**Re: Stone Age Climbing Gym
6110 Alameda NE
Request for Certificate of Occupancy
Transportation Development Final Inspection
Engineer's/Architect's Stamp dated 4-23-19(DRB) (C18D086A)
Certification dated 7-15-20**

Based upon the information provided in your submittal received 7-22-20, Transportation Development cannot approve the release of Certificate of Occupancy for the above referenced project.

# ACCESSIBLE PATH BETWEEN STONE AGE AND TIN CAN ALLEY

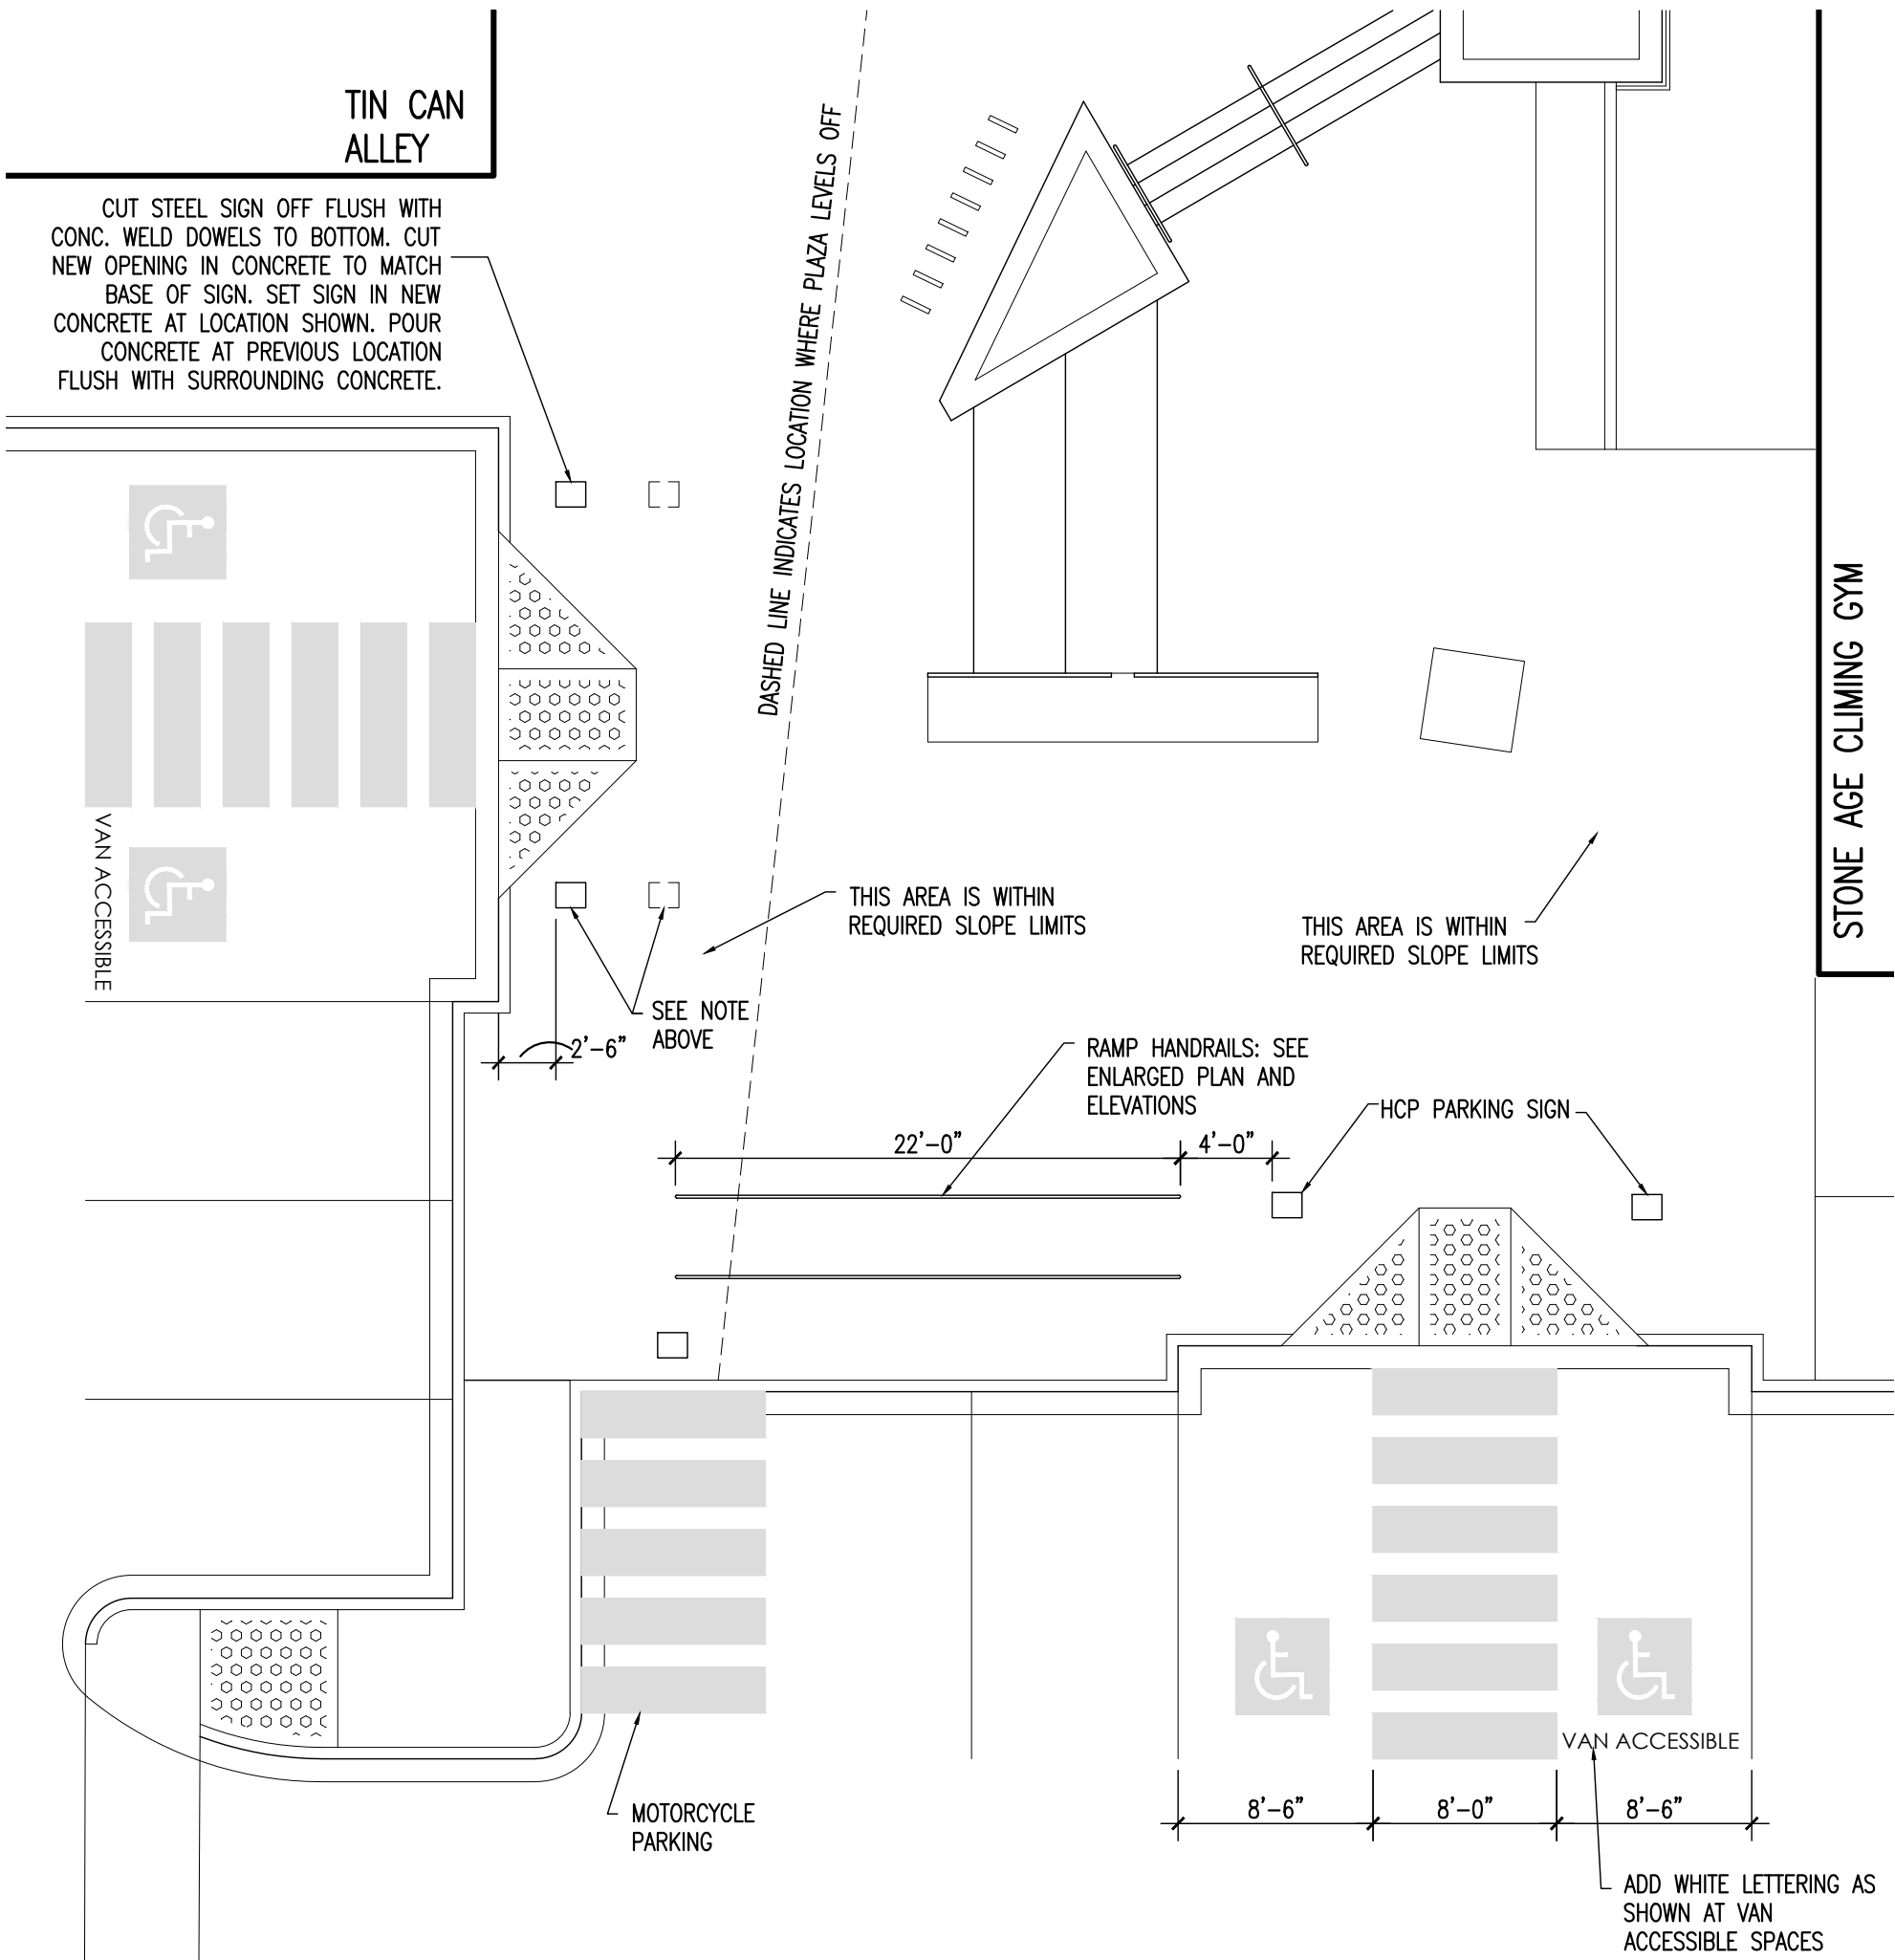
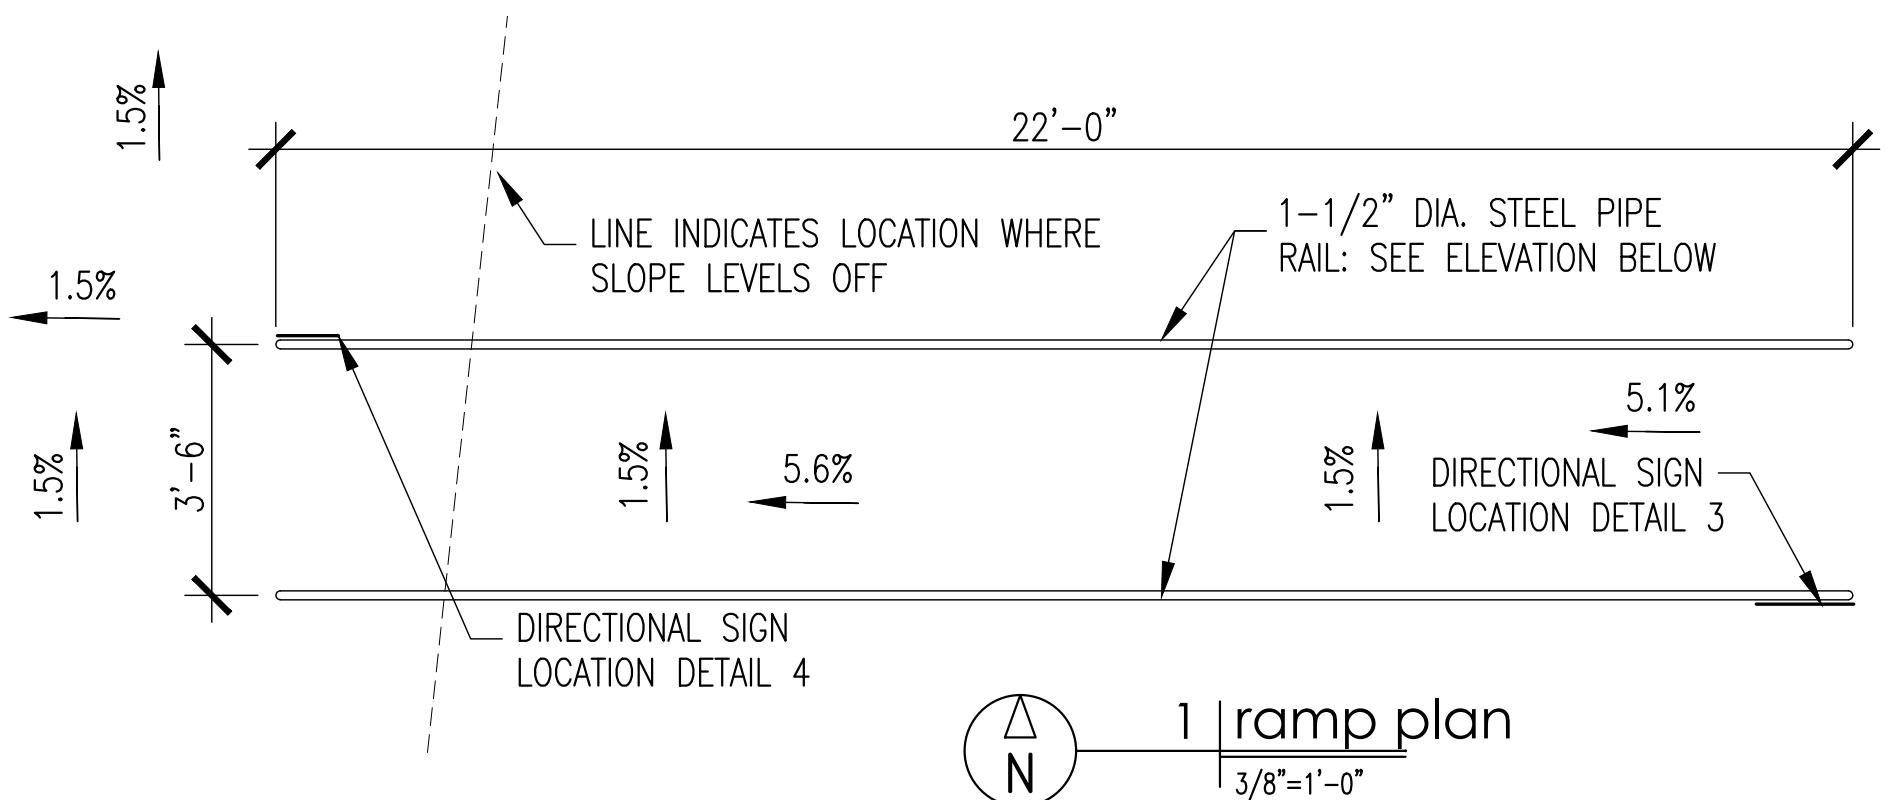
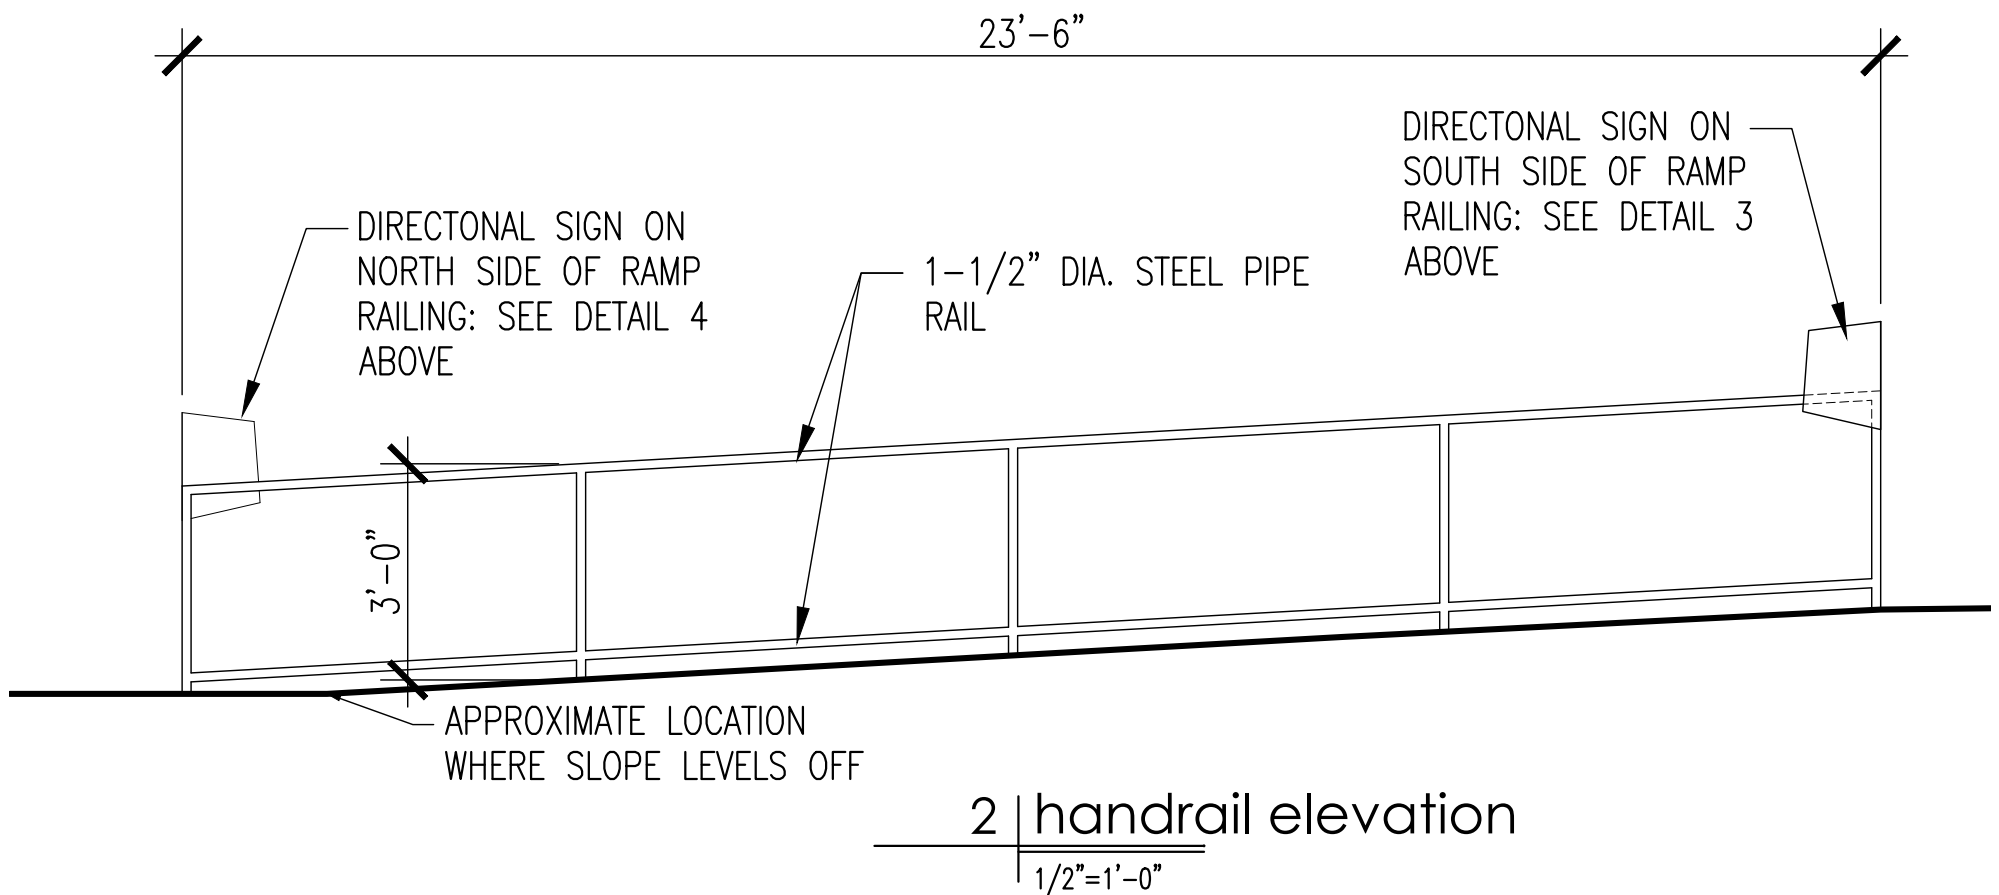
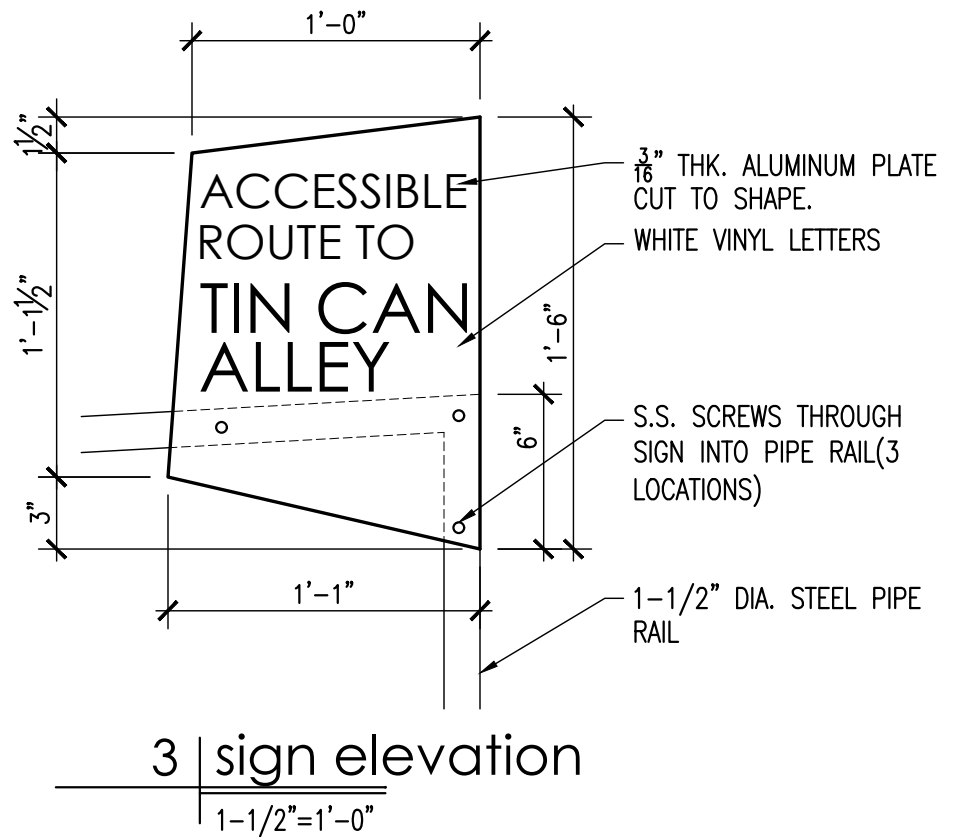
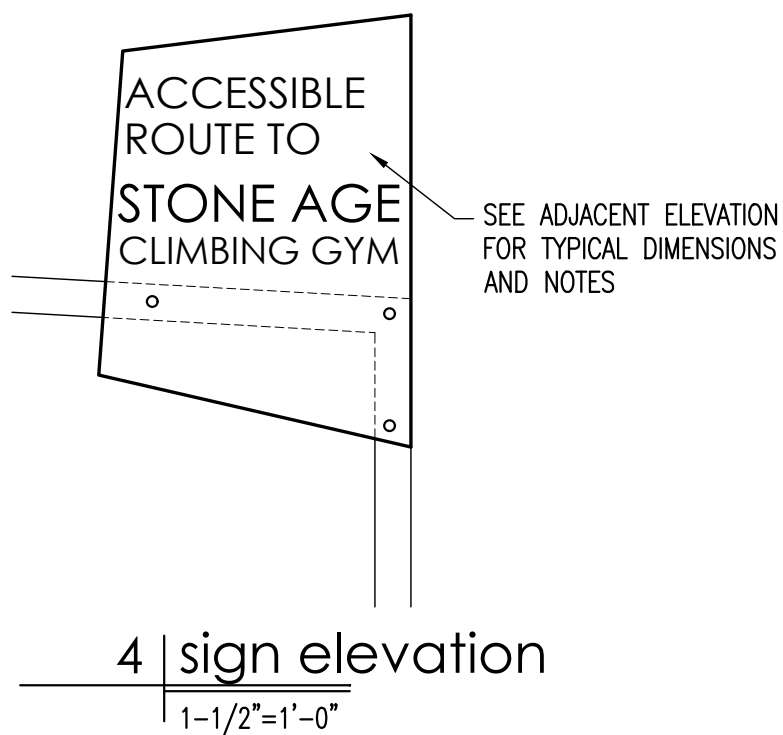
- ADA ramp landings need to be 2.0% in all directions. Please correct. (See attached plan for location)
- Please complete Curb and Gutter (See attached plan for location)
- Cross over from Tin Can Alley ADA stalls to Stone Age not ADA compliant. Please add something to inform customers cross over not ADA compliant. (See attached plan for location).
- Please stamp and date certification letter.
